## Planning Application Response

<b>Local Authority:</b>	Barnsley
<b>Detail:</b>	MU1 –Hybrid application for residential development of 1,760 dwellings, construction of link road, Phase 1 residential development of 229 dwellings, outline permission for 1,531, primary school, shops and community facilities
<b>Planning Ref:</b>	2021/1090 - Residential
<b>Deadline:</b>	20 <sup>th</sup> October 2021
<b>Submitted by</b>	Trans Pennine Trail Officer
<b>Response to:</b>	<a href="mailto:DevelopmentControl@barnsley.gov.uk">DevelopmentControl@barnsley.gov.uk</a>
<b>Submitted:</b>	15 <sup>th</sup> October 2021
<b>Summary</b>	<p>The Trans Pennine Trail national office welcomes the opportunity to respond to this planning application.</p> <p>Whilst the TPT is not directly impacted by the site it is imperative to recognise the essential links needed to the Trail to enhance the sustainable transport offer of the site.</p> <p>There are many areas within the documentation provided where it isn't clear what footways / multiuser refer to – this was noted in our original consultation response. To enable consultees and developers to have a clear understanding of what will be delivered in terms of sustai

2.6 EXISTING PEDESTRIAN NETWORK

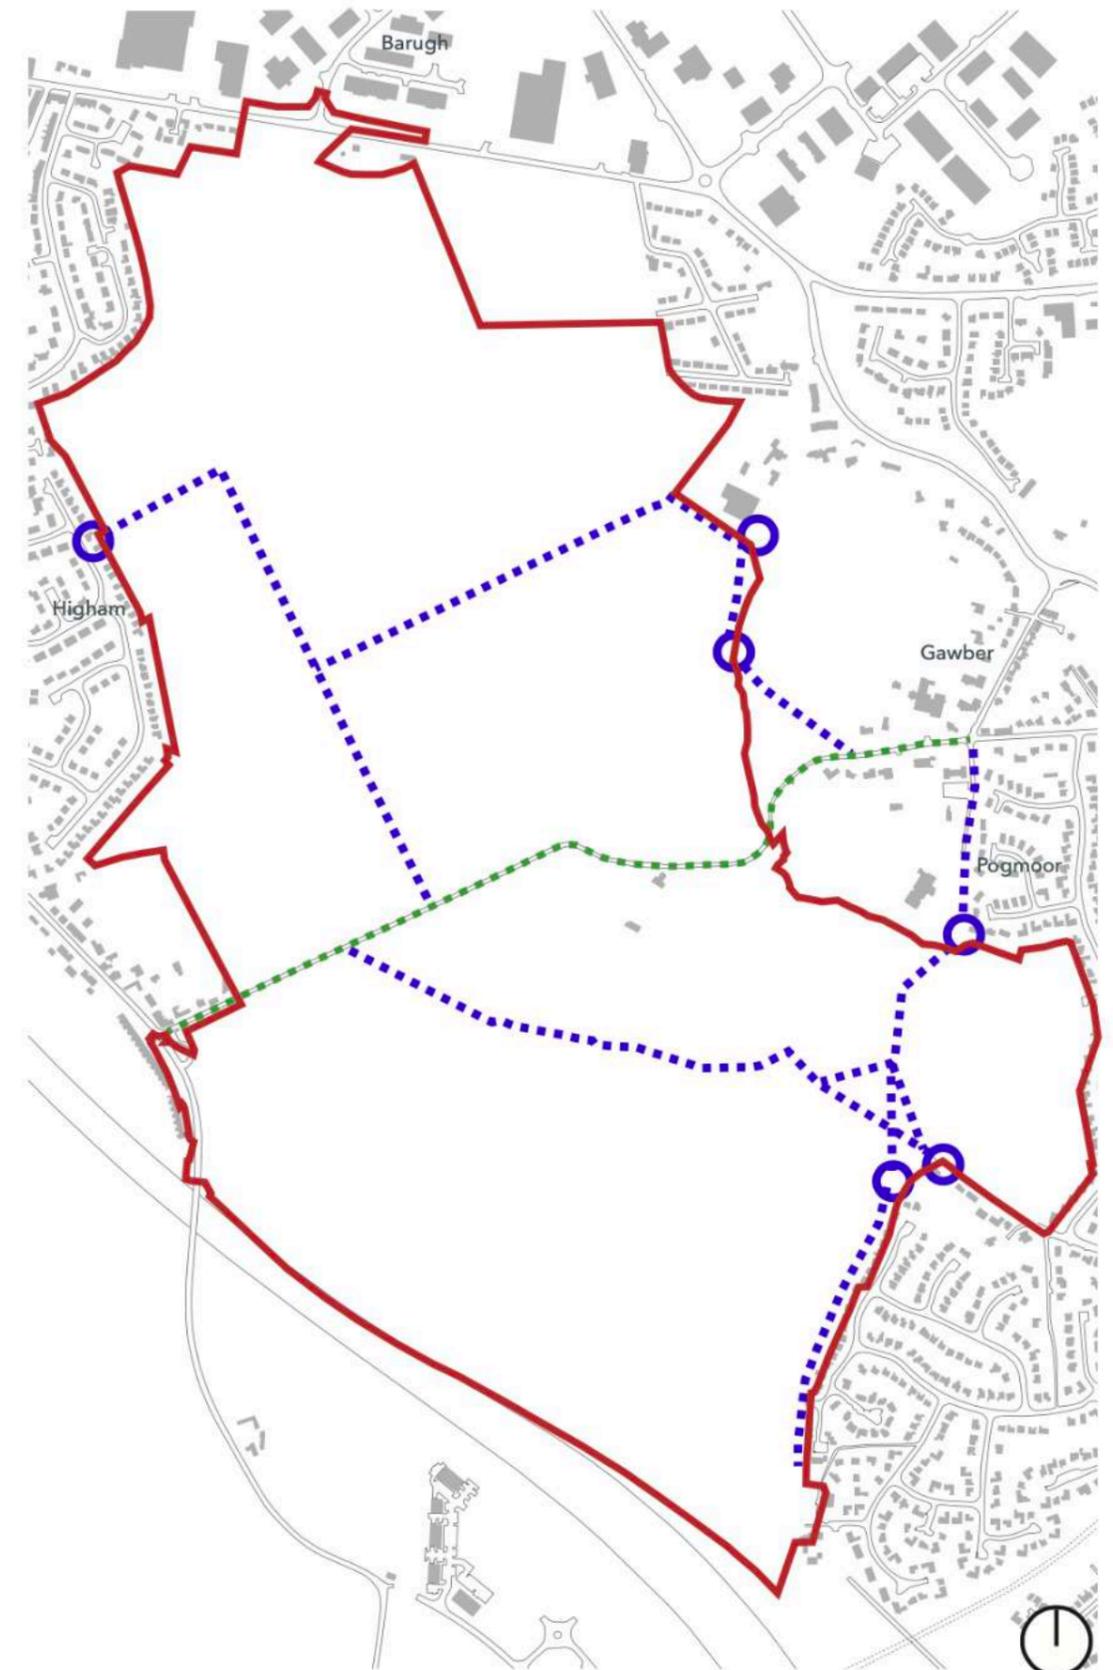
2.6	There is no clear indication if the current routes are footways, cycleways or bridleways. It is important for the agent / developer to provide clear detail as this will impact on the user type for the public rights of way (as noted above).
